Our Ref: EN020028

Date: 18 November 2024

Application by Morgan Offshore Wind Limited and Morecambe Offshore Windfarm Limited for an Order Granting Development Consent for the Morgan and Morecambe Offshore Wind Farms Transmission Assets project

Advice following issue of decision to accept the application for examination

Onshore Statutory and Non-Statutory Nature Sites (Doc B14) and Onshore Historic or Scheduled Monument Sites (Doc B16)

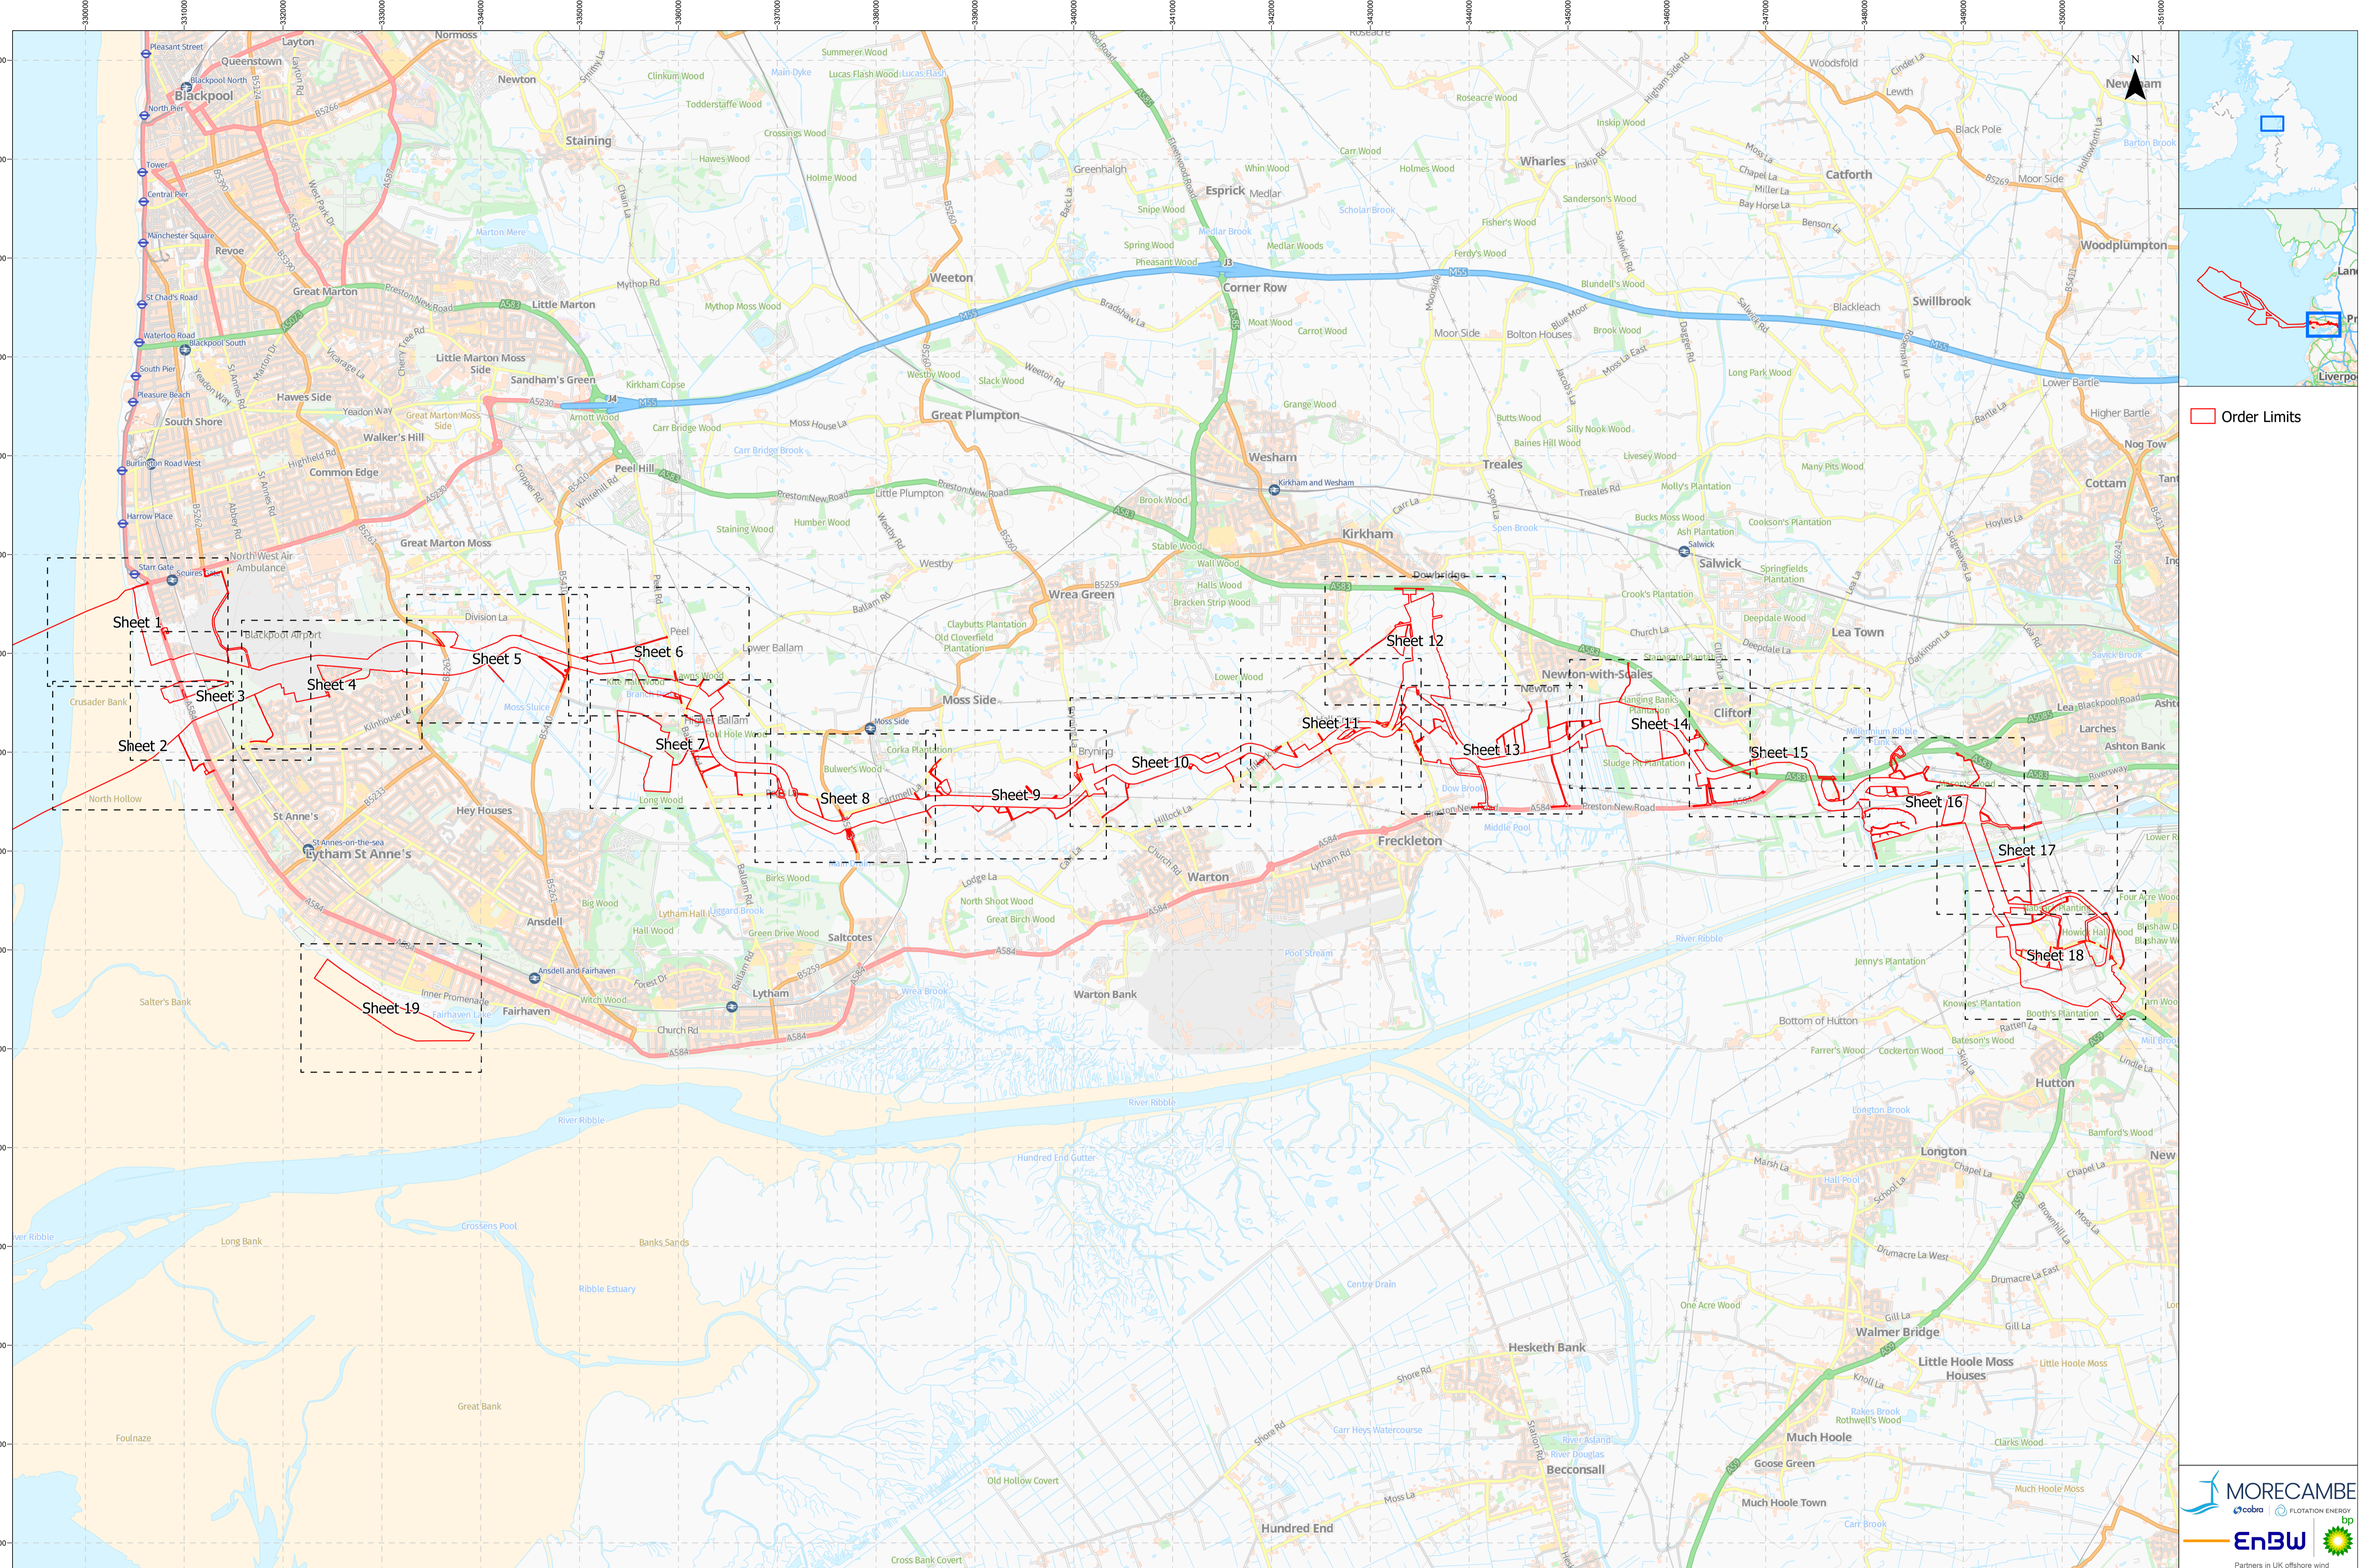
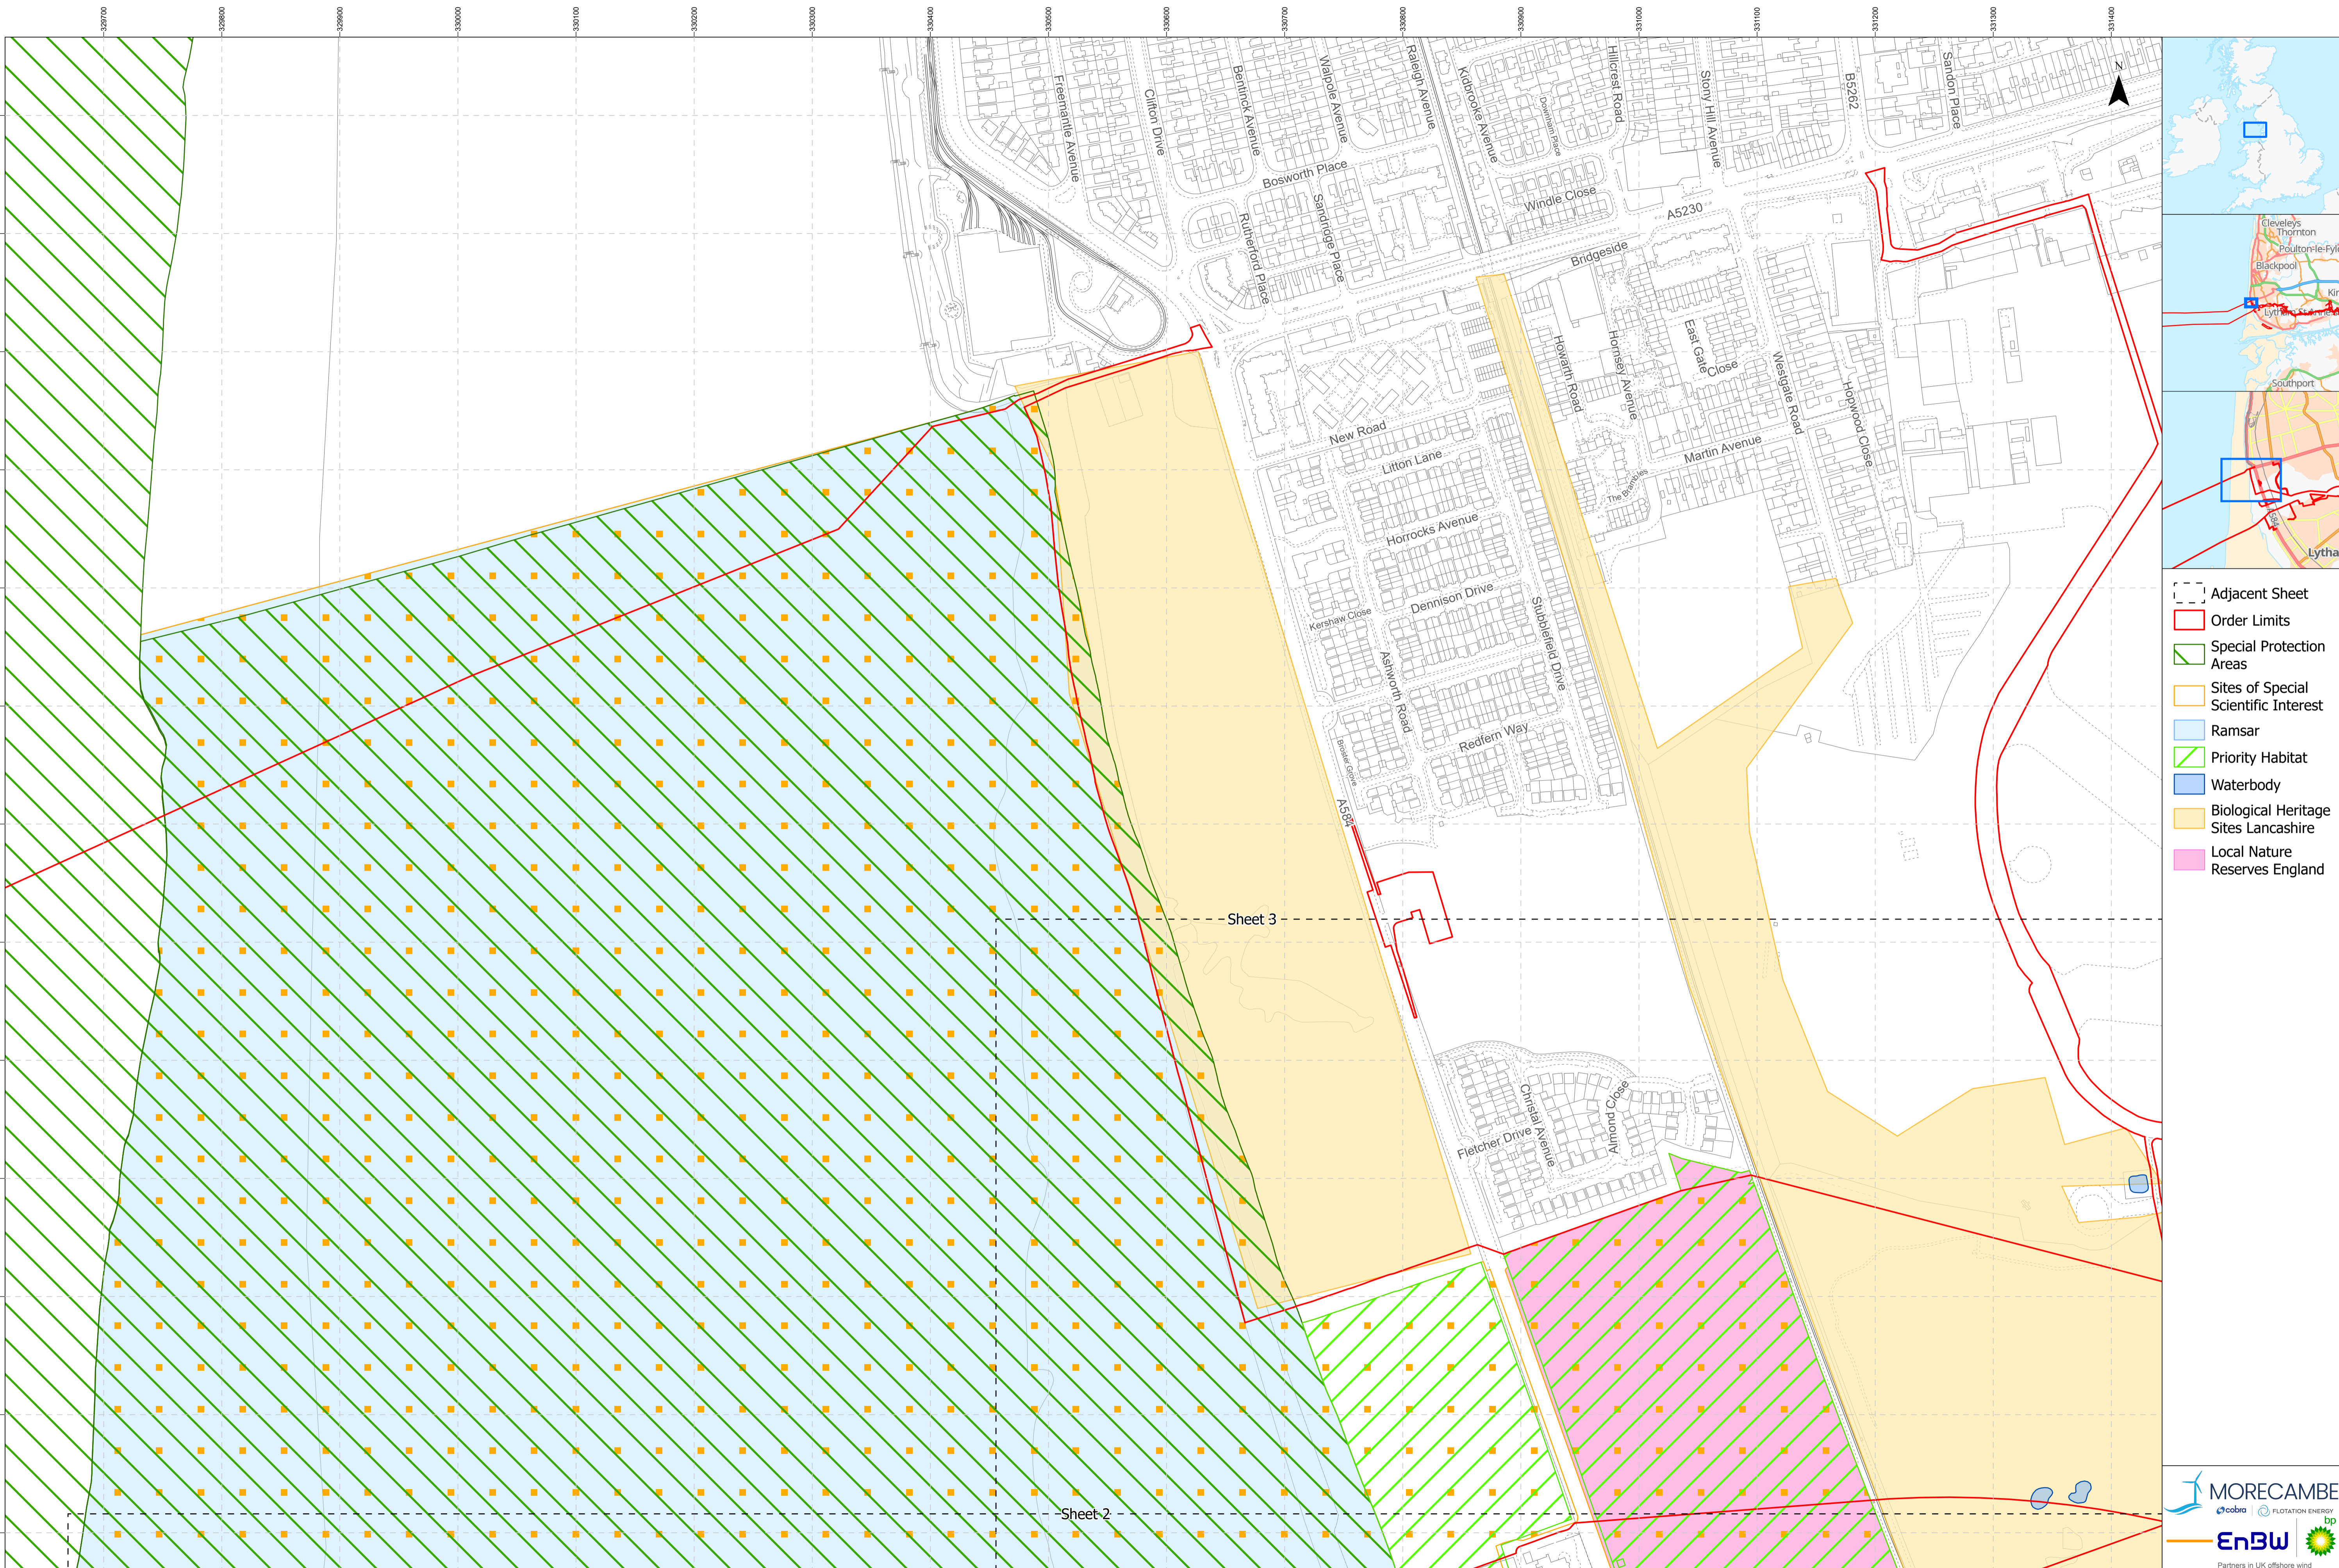
The plans showing Onshore Statutory and Non-Statutory Nature Sites (and Waterbodies in a River Basin Management Plan) (Doc B14) and Onshore Historic or Scheduled Monument Sites (Doc B16) present the sites, rivers or historic assets, however these are not labelled (unlike the equivalent offshore plans). The Applicants are advised to provide an updated set of figures with appropriate labelling of the features being represented.
